re: Grading and Site Servicing Plan Review
Proposed Self Storage Development
75 Michael Cowpland Drive – Ottawa, Ontario

date: December 21, 2023

file: PG3798-MEMO.02 Revision 4

Landscaper:
Fotem

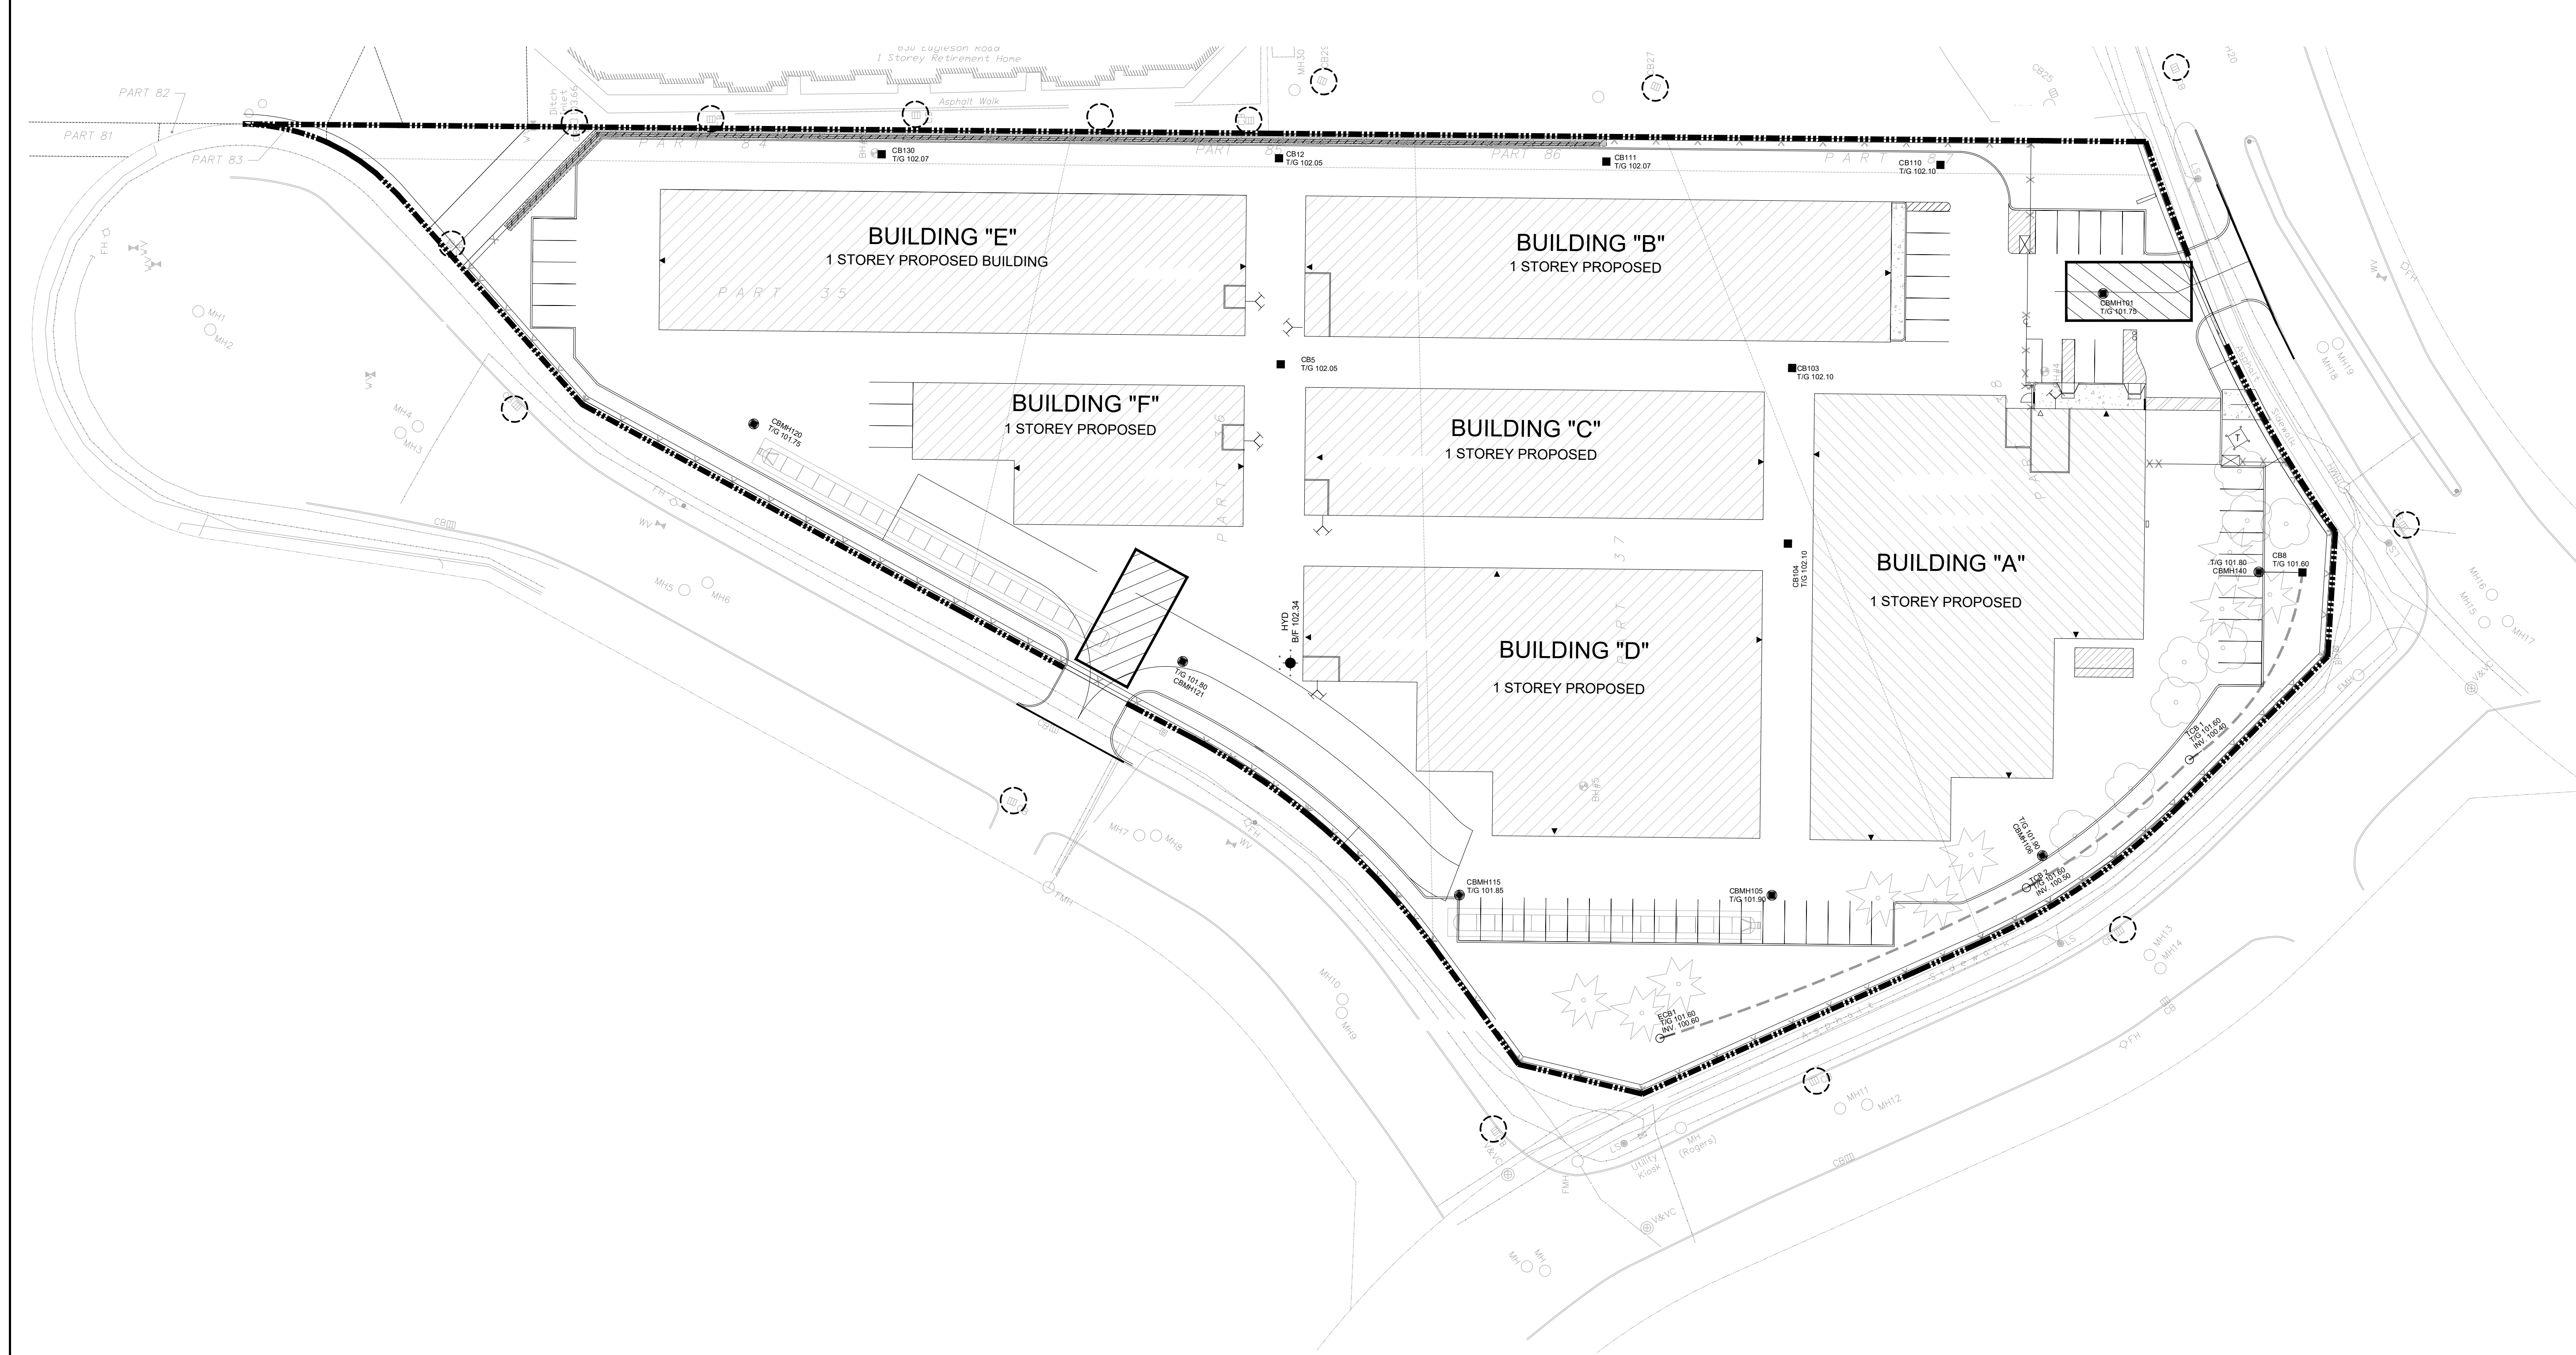
Based on our review of the aforementioned grading plan, the proposed grades around the proposed buildings and throughout the subject site are within the permissible grade raise restriction provided. Based on this, since grade raises are within our recommended grade raise restriction no lightweight fill will be required to accommodate the proposed grading. Therefore, the proposed grading is considered acceptable from a geotechnical perspective.
